A303 Amesbury to Berwick Down

**8.3 (2) – Statement of Common Ground– Historic Buildings and
Monuments Commission for England**

**STATEMENT OF COMMON GROUND – Historic Buildings and Monuments
Commission for England**

Regulation Number:	Regulation 5(2)(q)
Planning Inspectorate Scheme Reference	TR010025
Application Document Reference	8.3 (2)
Author:	A303 Project Team, Highways England, and Historic England

Drawing Title
STRUCTURES DRAWINGS
EASTERN TUNNEL PORTAL
REGULATION 5(2)(o)
SHEET 11 OF 13

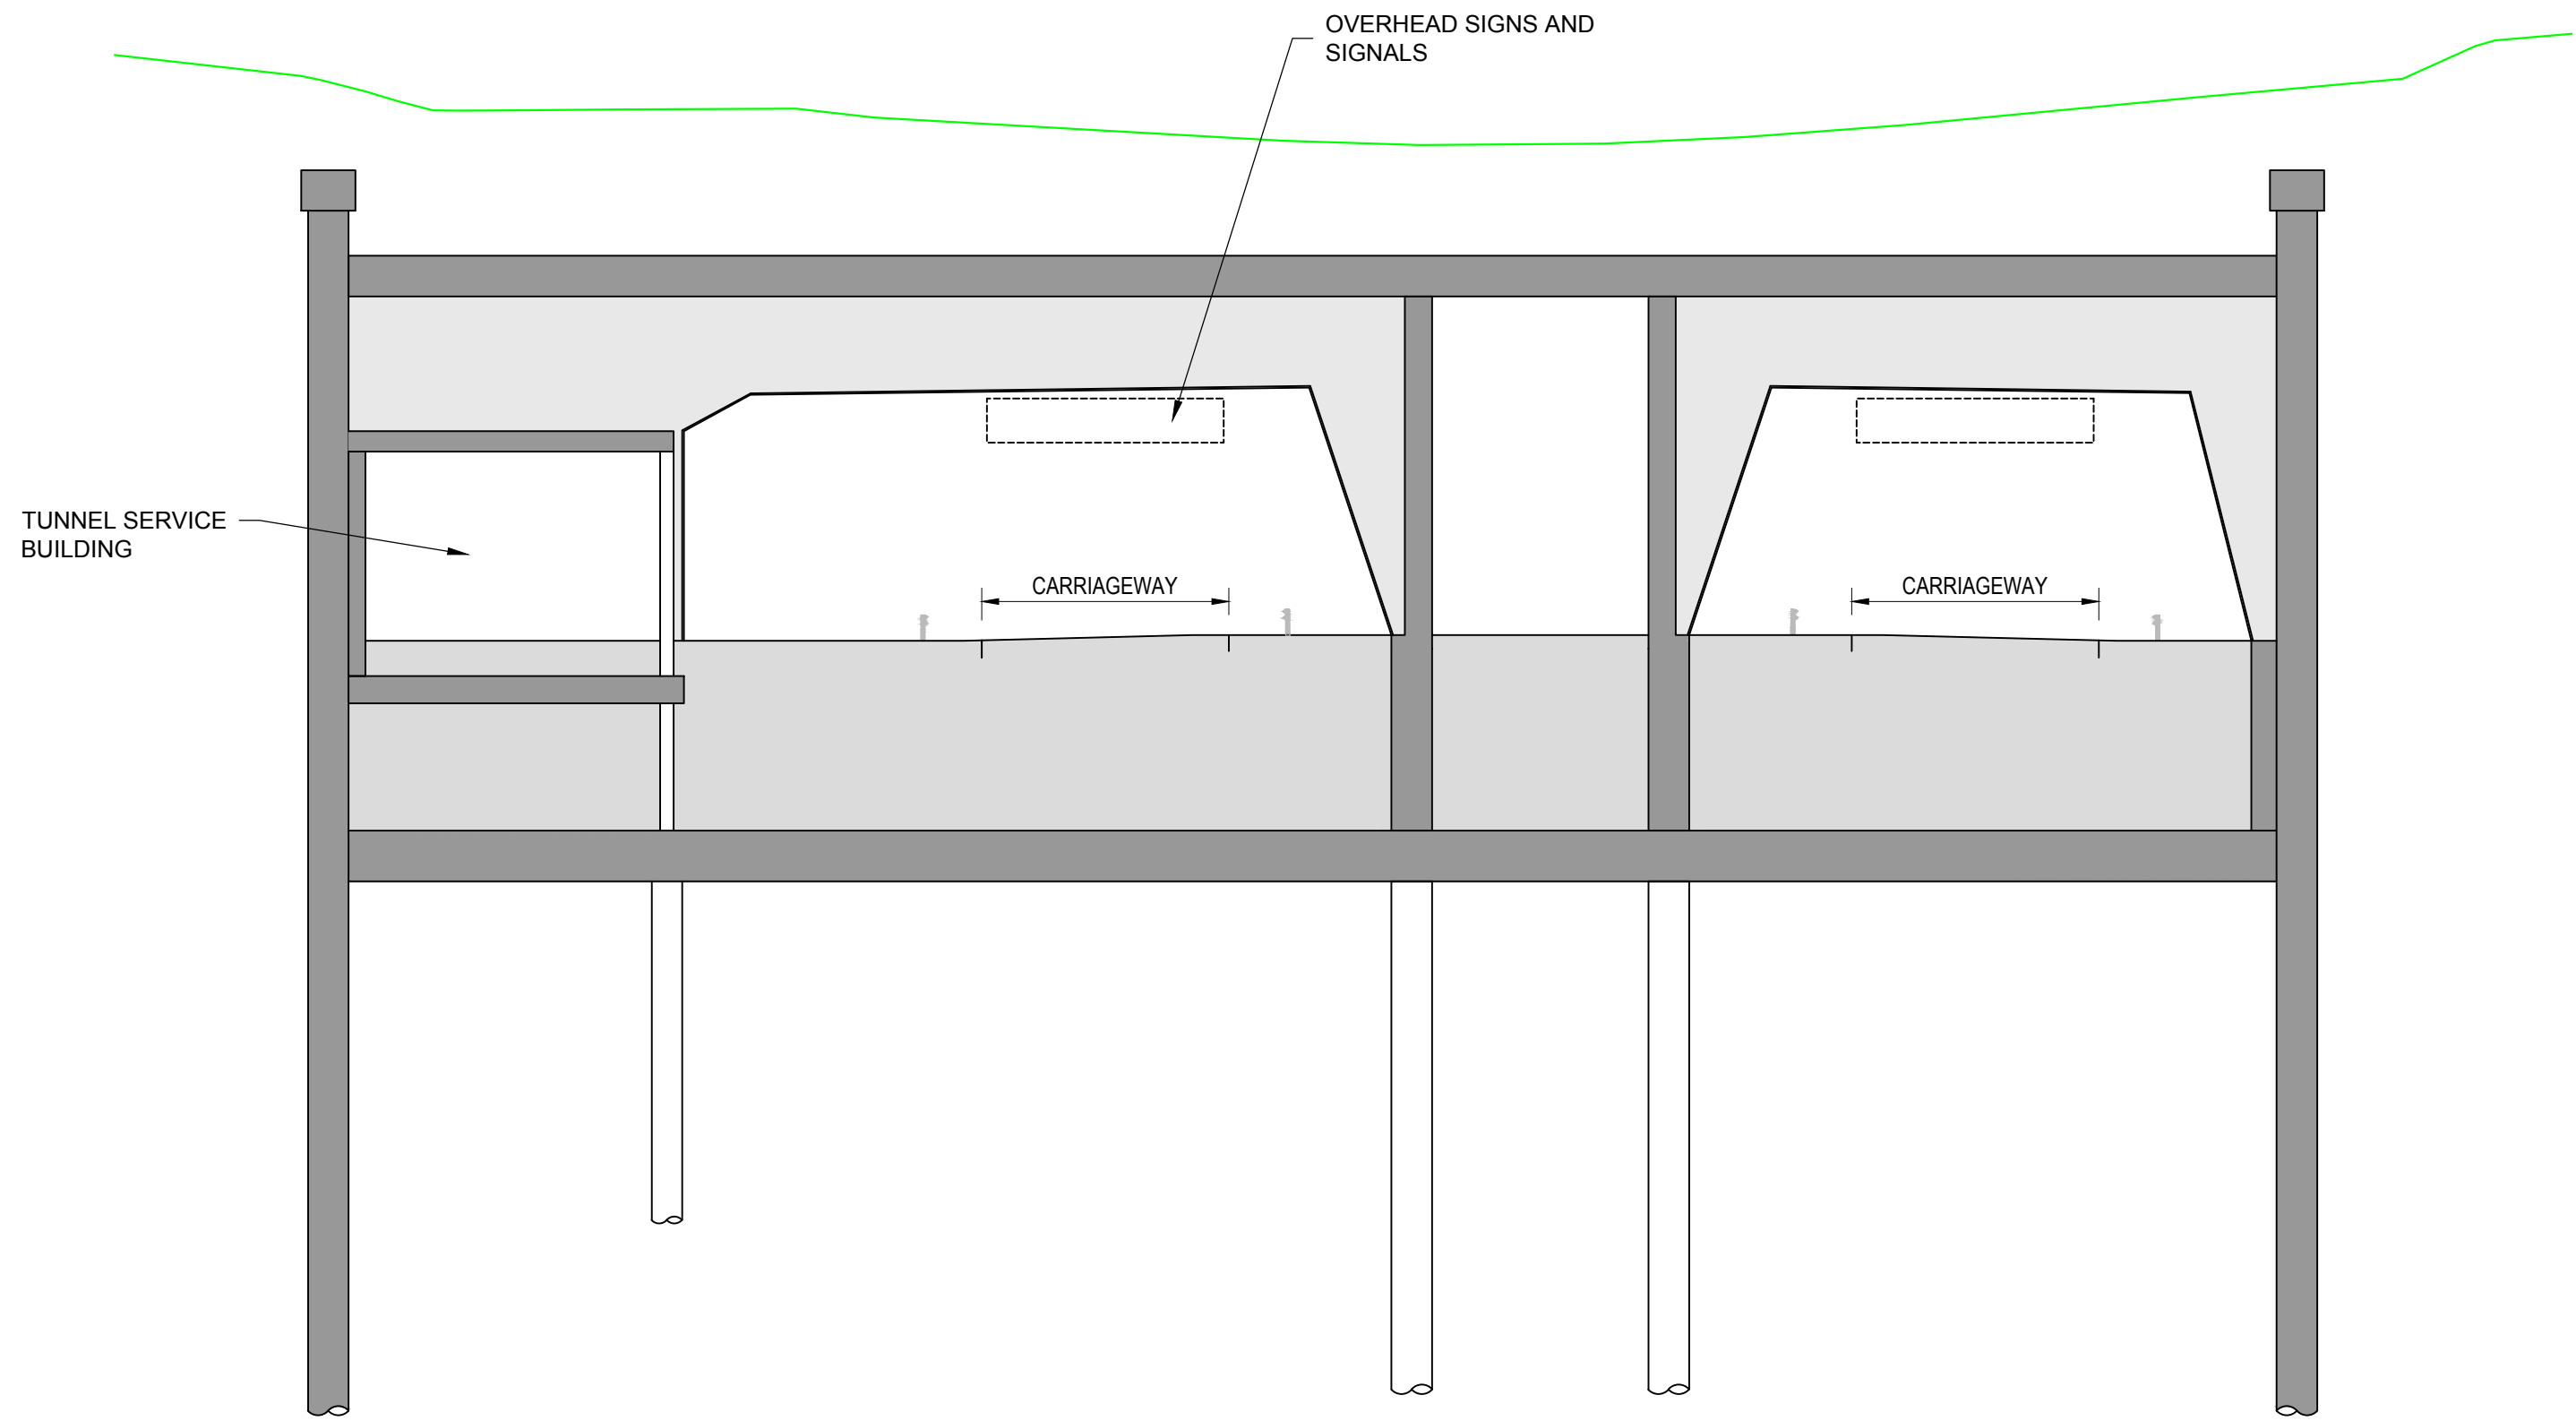
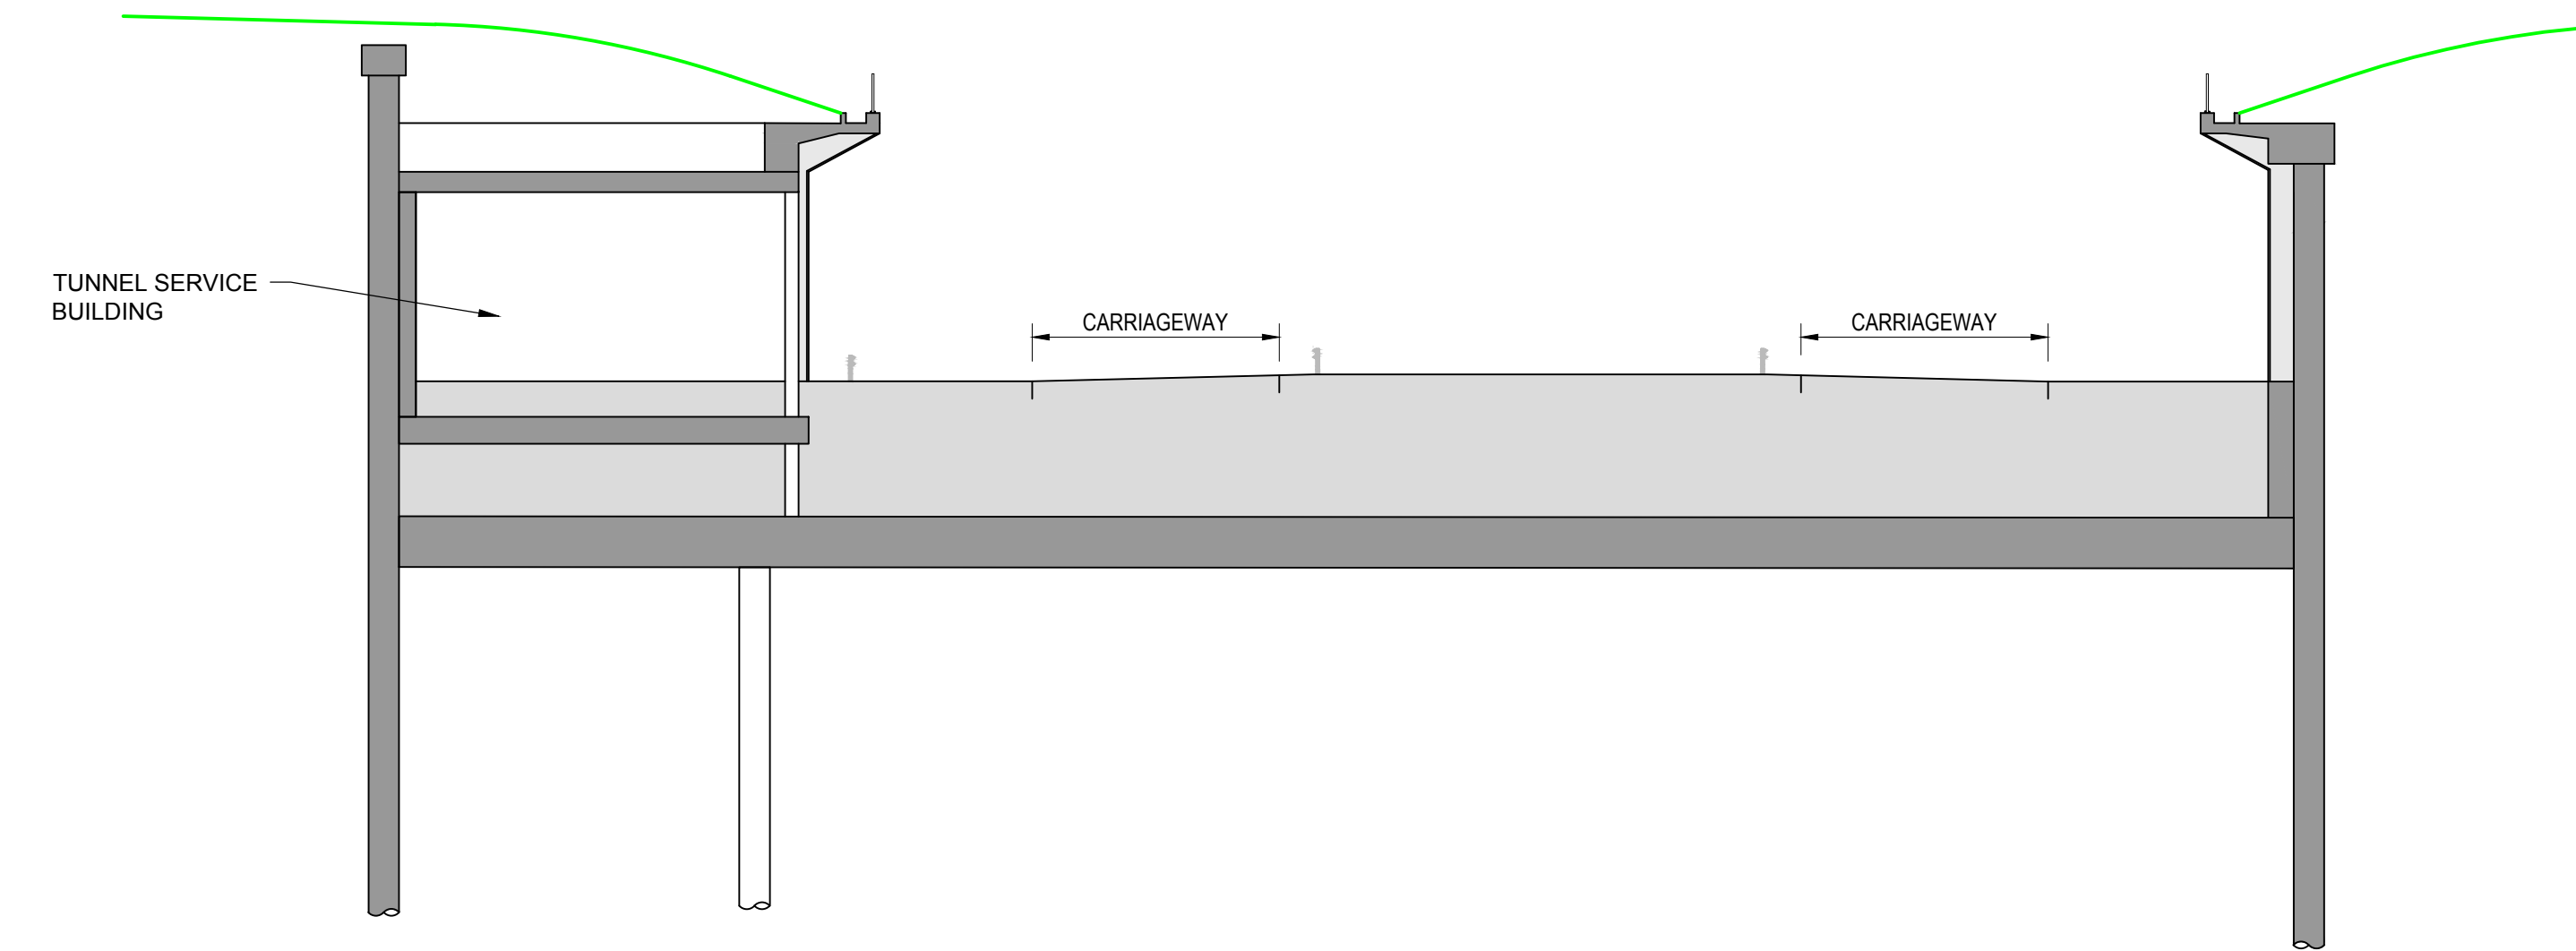
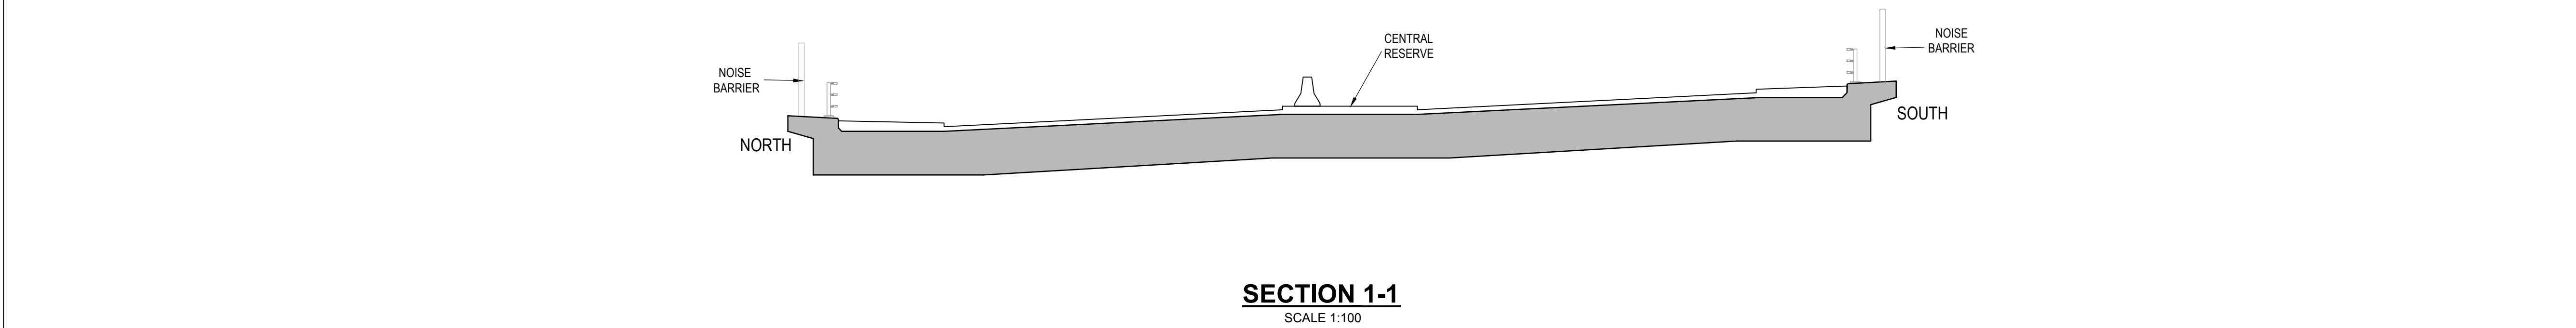
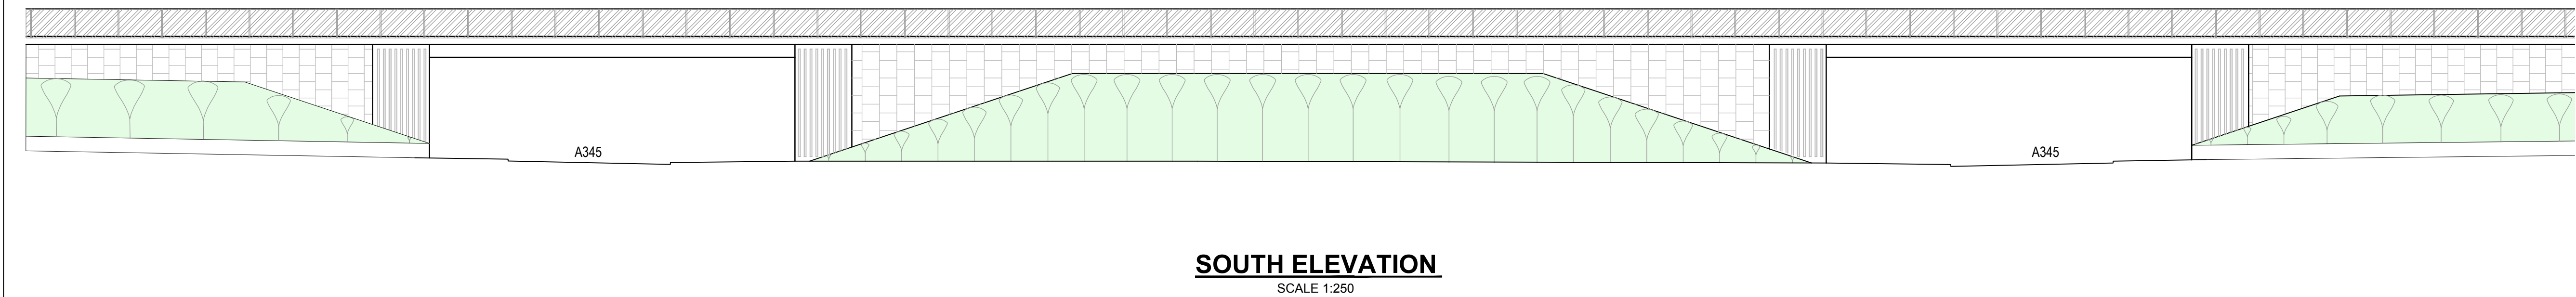
Issue Ref	Doc Ref	Paragraph Reference	Sub-section	HBMCE Comment	Highways England Response	Status
	[REP4-085]	Section 9.3, page 28	<p>visualisations</p> <p>Paragraph 9.2.1</p>	<p>representations for key elements of infrastructure within the WHS, including the western tunnel portal and its extension, the eastern tunnel portal, the articulation and form of open cutting retaining walls and the design, construction, form and appearance of Green Bridge 4.</p> <p>The Written summaries of oral submissions put at Issue Specific Hearings [REP4-85] confirmed that within the Written Representations HBMCE advised that it was essential that the complement of visualisations submitted demonstrated to the Examining Authority the full range of visual impacts on the OUV and experience of the Stonehenge WHS and the designated and non-designated heritage assets in that same landscape (Section 7.5.18). We welcome the further requests for additional visualisations from the Examining Authority, some of which were produced and submitted at Deadline 3.</p> <p>We are pleased to note that further visualisations have been submitted. However there remain some visualisations and design representations that we would like to</p>	<p>particular photomontages and CGI visualisations have been presented within the LVIA Chapter (Chapter 7 [APP-045]) and Cultural Heritage Chapters (Appendix 6.9 [APP-218]) of the ES. Design and visual representations will be developed through the detailed design process.</p> <p>The further detailed design of the portal and its associated infrastructure will be sensitive to its WHS context, following Highways England's guide 'The Road to Good Design' and will be developed in consultation with HBMCE. The OEMP (the final version of which was submitted at deadline 9) [REP9-013] has been updated in consultation with HBMCE to include a vision and design principles section and process for consultation in the development of detailed design including specific design principles relating to the portal and its associated infrastructure.</p> <p>It should be noted that the photomontages are based on the Environmental Masterplan [APP-</p>	Highways England that the issues that HBMCE has raised have been broadly addressed
